Our ref: DOC21/288764-7

Response to Submissions for Project Energy Connect (NSW – Western Section) (SSI-10040)

ATTACHMENT A: Detailed comments on Project Energy Connect (NSW – Western Section) (SSI-10040) - Aboriginal Cultural Heritage

Figure 3.1 Proposal study area, survey area (excluding section not surveyed) and heritage study corridor

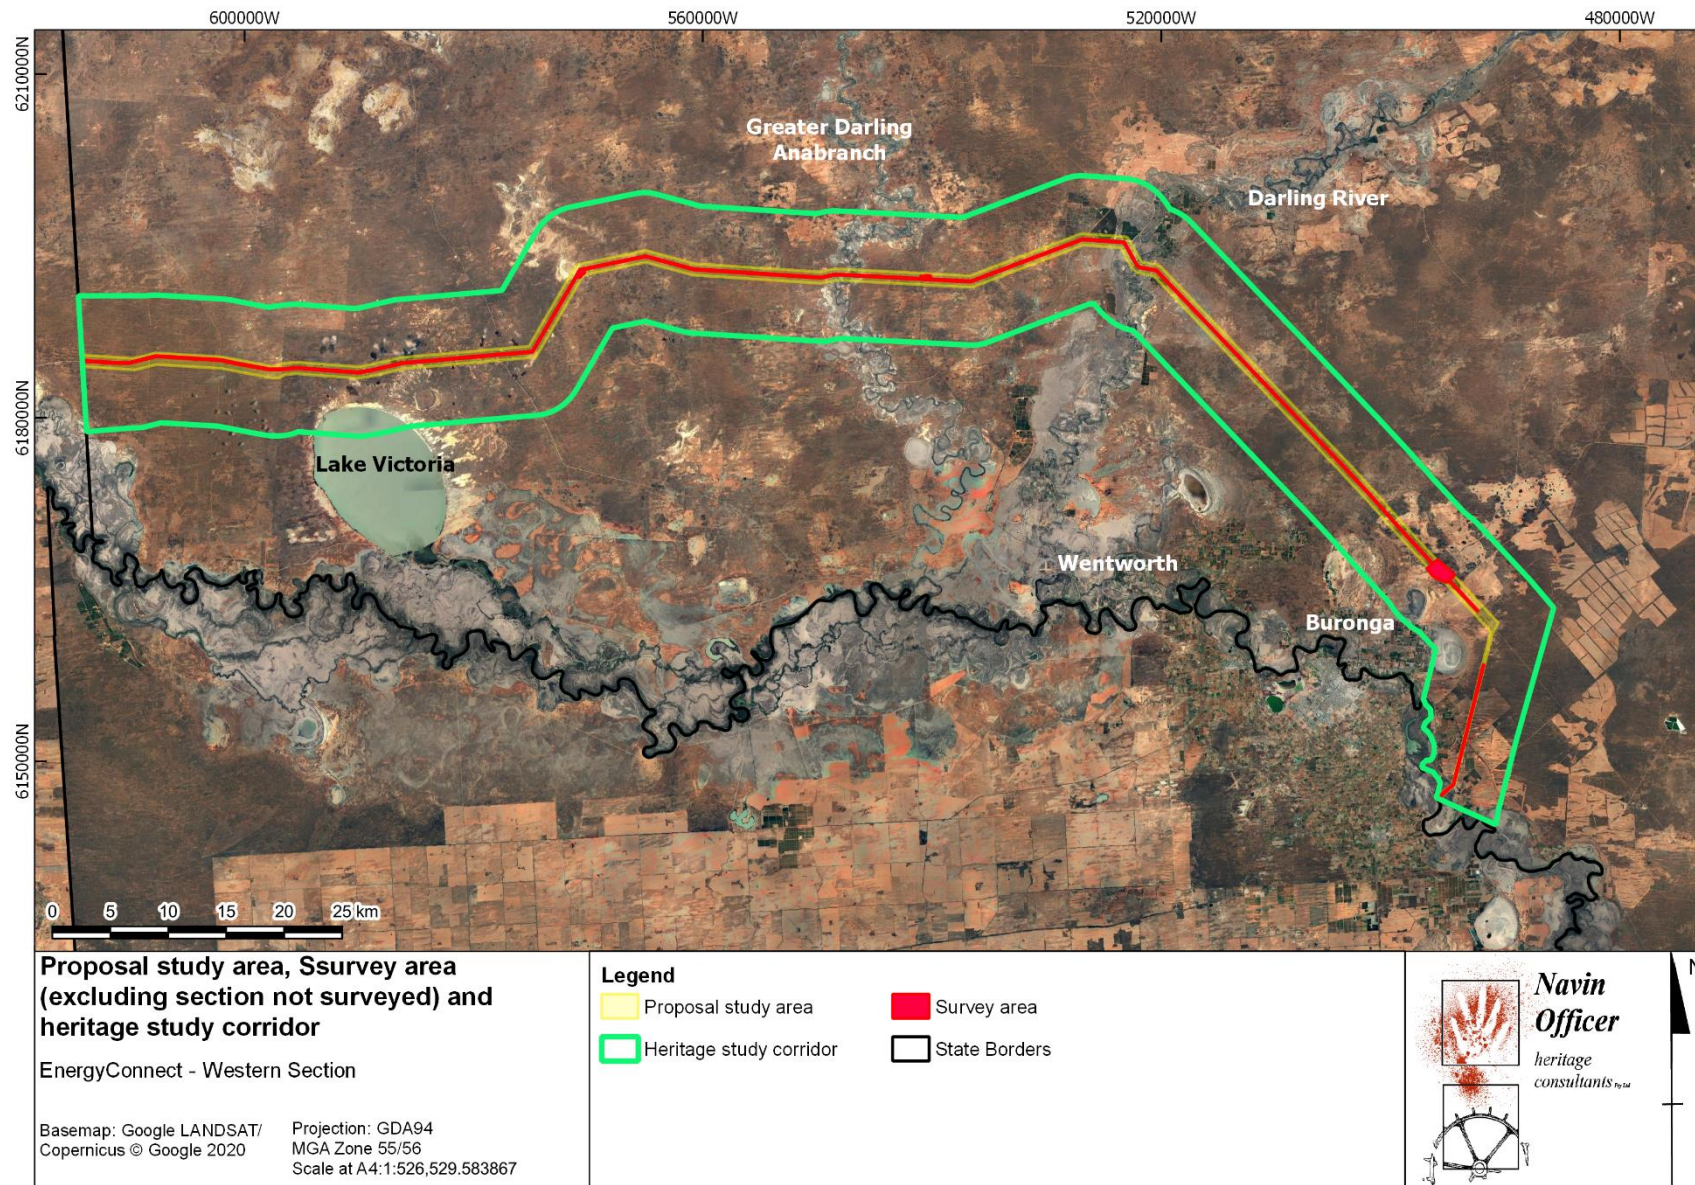
In order for this development to proceed and to ensure that the SEARs are complied with, comprehensive pedestrian survey of the entire alignment needs to be undertaken, test excavations need to be conducted, and the Aboriginal Cultural Heritage Assessment and Statement of Significance updated to reflect the results of these assessments.

Heritage NSW Aboriginal cultural heritage review/ submissions 24/11/2020	TransGrid 2021 response to submissions	Heritage NSW review response
<p>An approx. 10km section east of Gol Gol Lake could not be assessed due to landowner access issues. Heritage NSW advised this would need to be assessed, or if any alternate alignments were undertaken to alleviate land access issues, then these would need to be assessed as per SEARs.</p>	<p>Mitigation measure AH3 provides that, survey will occur with RAPs in areas that were outside of original survey (TransGrid 2021: 38)</p>	<p>What is proposed is not a mitigation method, but an assessment. As per previous comment, to address the SEARs and proper planning and approvals processes, assessments need to be completed.</p>
<p>The ACHA does not provide survey information in accordance with Requirements of the Code of Practice for Archaeological Investigation of Aboriginal objects in NSW (DECCW 2010) (CoP) and the revised SEARs.</p>	<p>CoP survey data was contained in Appendix 4 of the ACHA. This was clarified between discussions with Navin Officer and Heritage NSW and was sufficient to address requirements.</p>	<p>Noted. The requirement for completion of surveys and the need to test excavations was also discussed.</p>
